From: Tom Errico <thomas.errico@tylin.com>
To: Jean Fraser <JF@portlandmaine.gov>
CC: David Margolis-Pineo <DMP@portlandmaine.gov>, Katherine Earley <KAS@port...>
Date: 5/13/2015 1:41 PM
Subject: Jewish Community Center

Jean - I have reviewed updated trip generation information provided by the applicant and have the following additional comments.

Drawing file: Plans / J0096-C-2-SITE PLAN.pdf

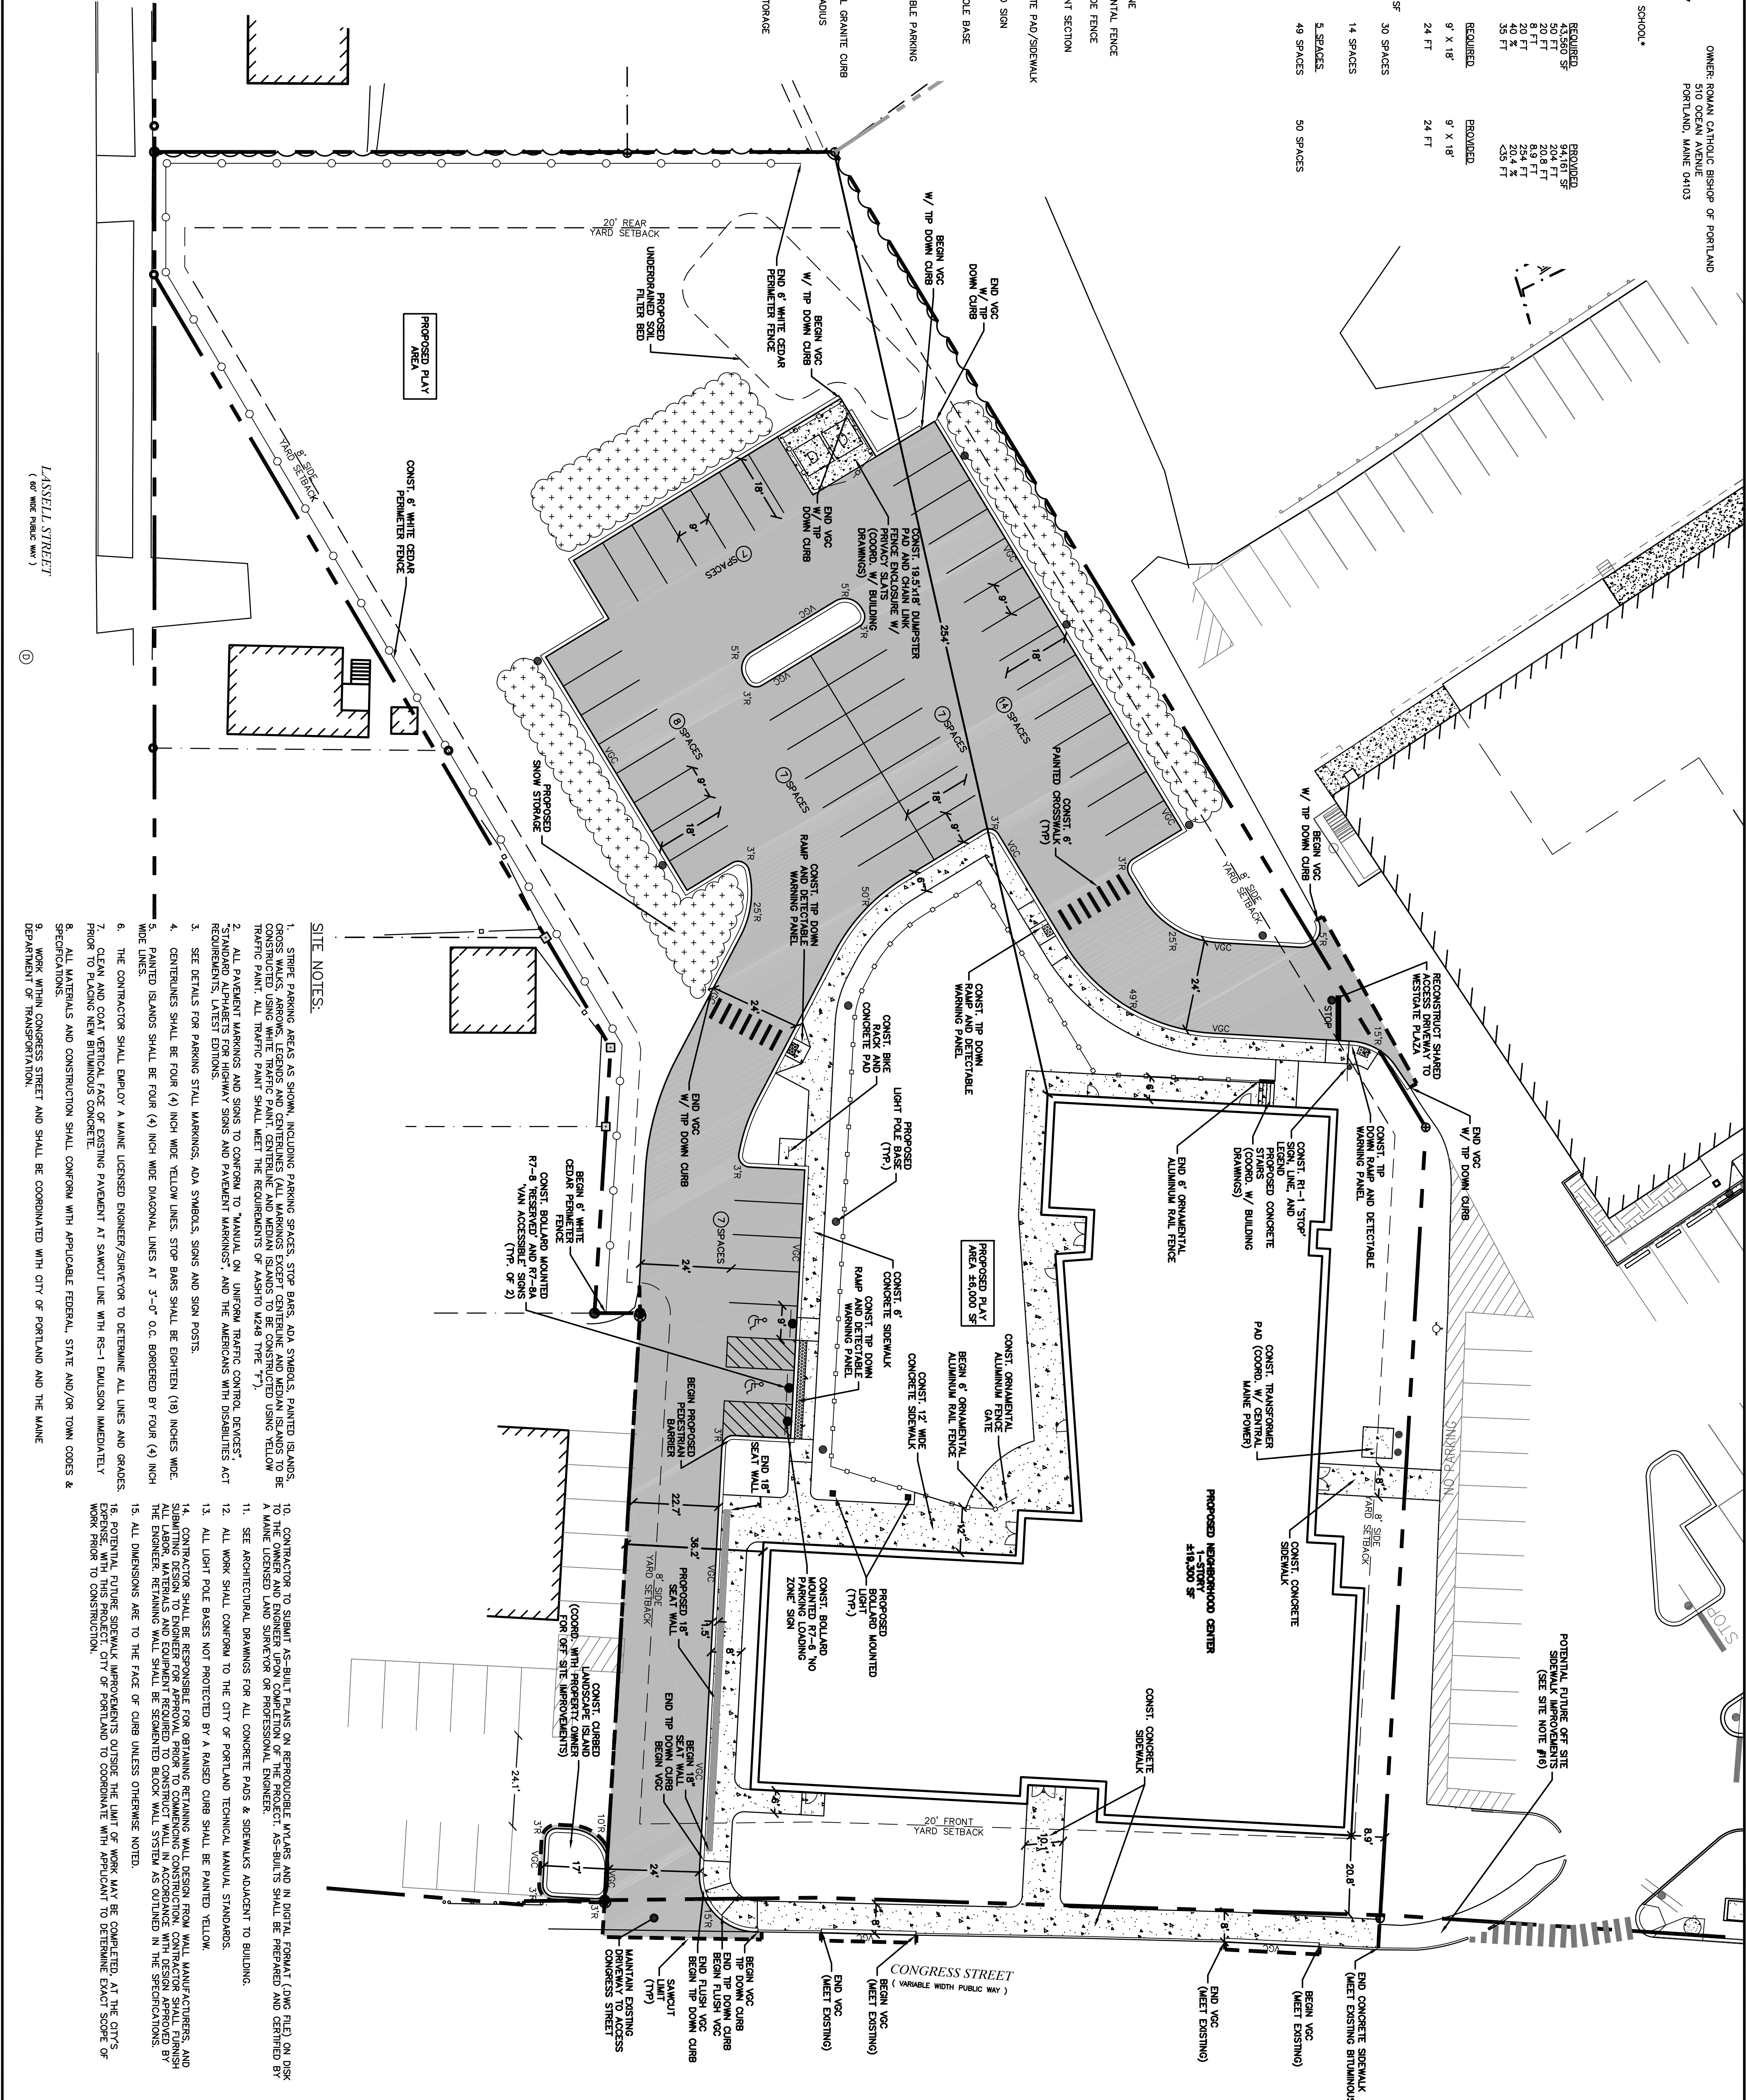
* The pick-up and drop-off of daycare and others will need to be carefully managed. Accordingly, the applicant should provide specific details on how this process will take place. This should include what building entrances will be used, sidewalk facilities between parking spaces and the noted entrance, etc. I would note that the pick-up/drop-off program must be managed such that vehicles are not parking along the driveway off Congress Street.
